Fleurie Nursery , Lake Lane.
Response to ADC Engineer questions.

For reference block names are as per drawing attached and abbreviations as shown in parenthesis are used throughout - southern tunnels (ST), southern glass (SG), eastern glass (E), northern (N).

Construction details v2

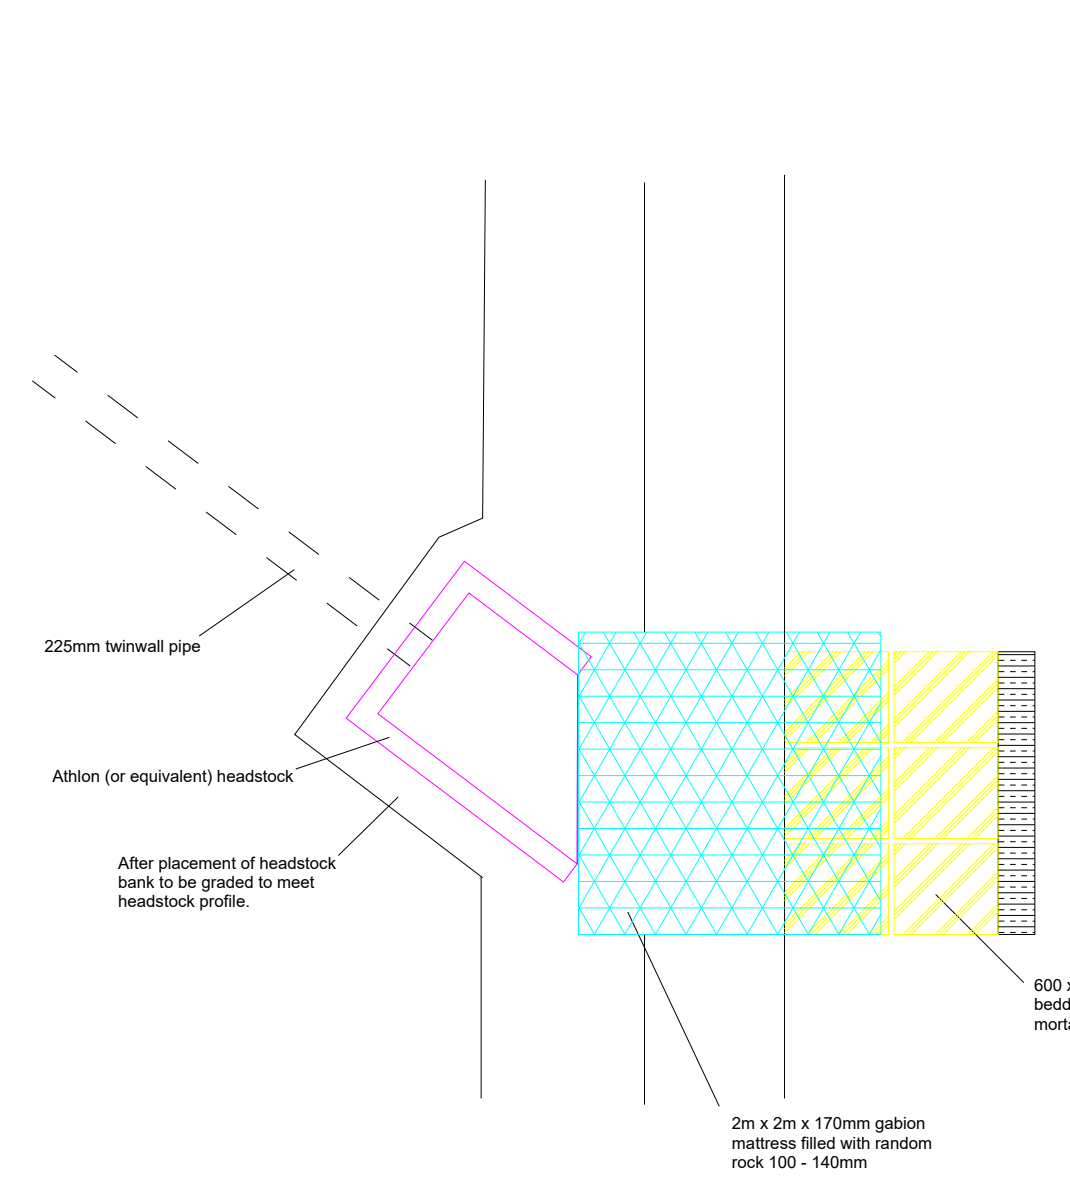
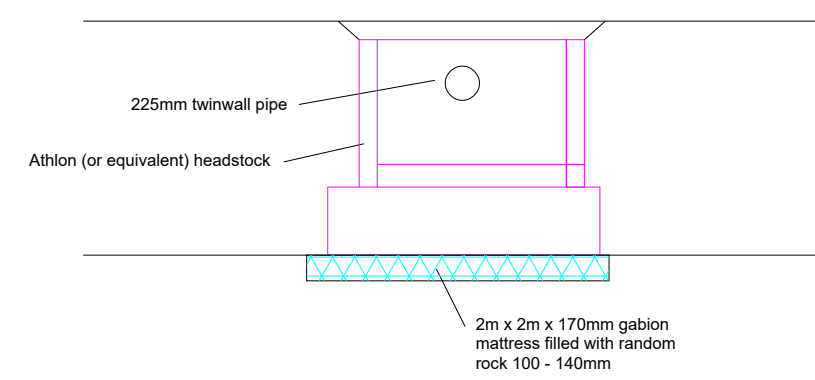
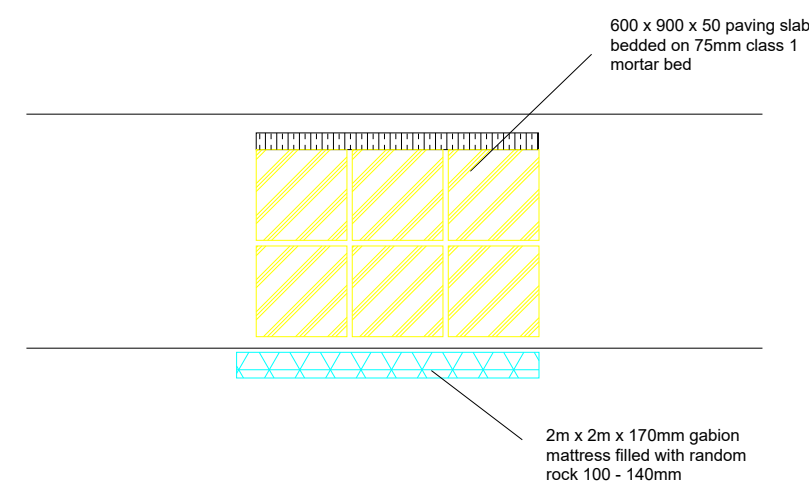
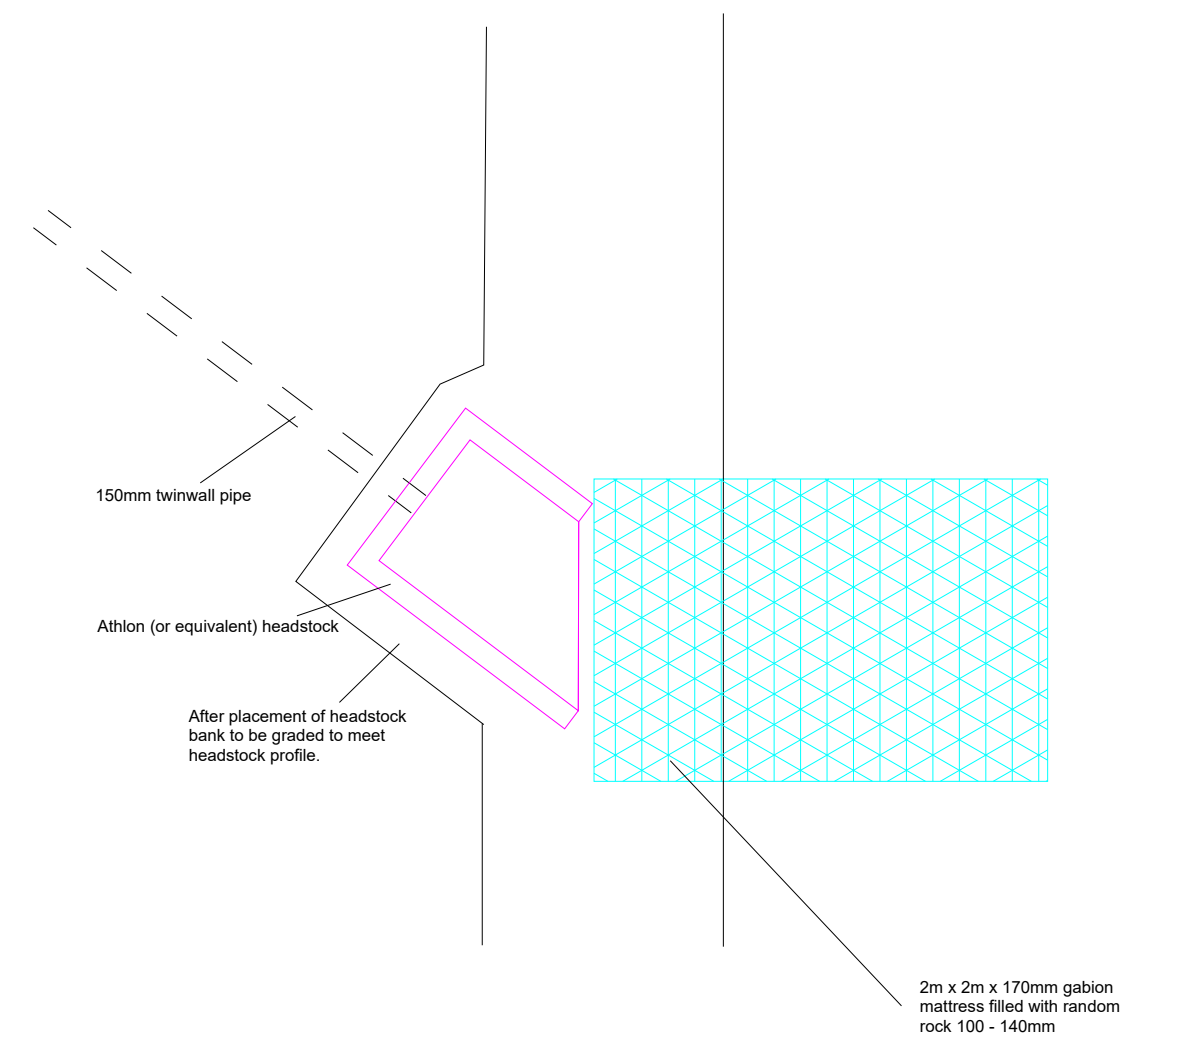
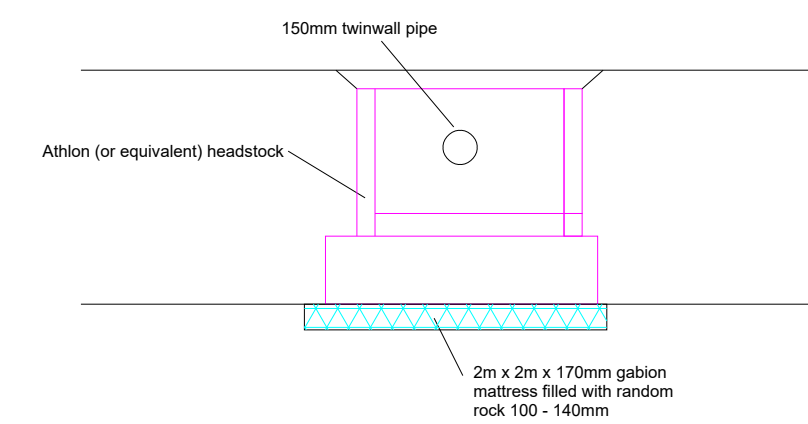
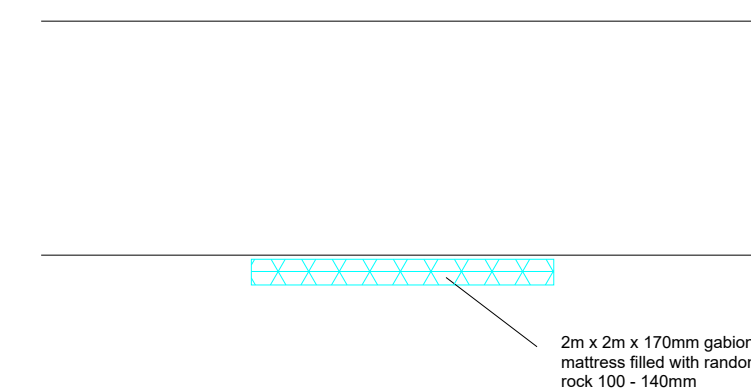
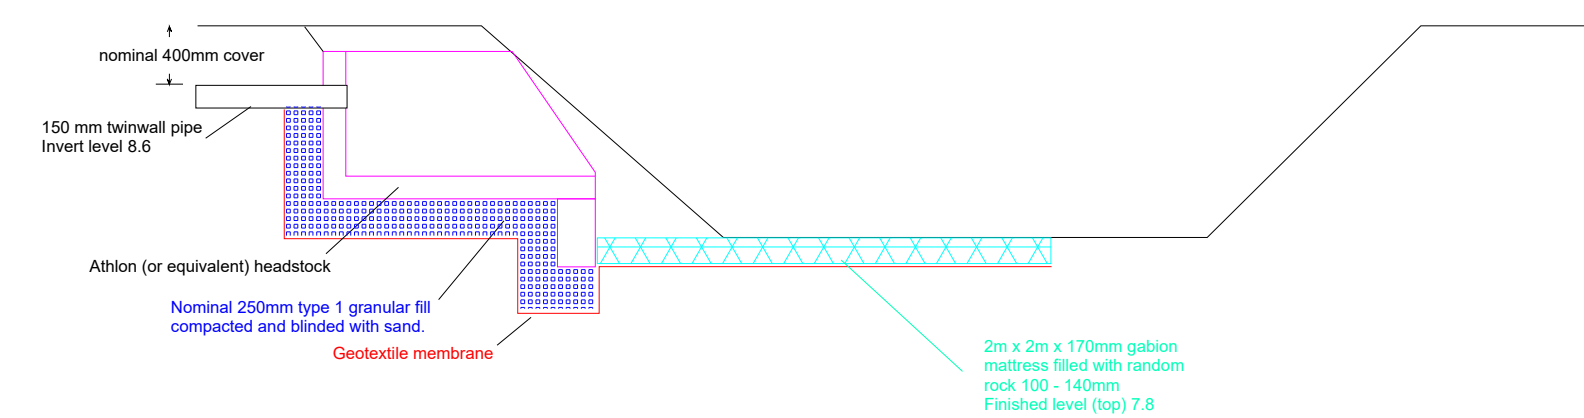
5d. Scheme drawings - outfalls

Standard Marshalls Spillway Headwall S40 Pipe Dia 150mm used, Manufacturer's details provided

Athlon MDPE flap valves to match the pipe diameter will be fitted to all outfalls.
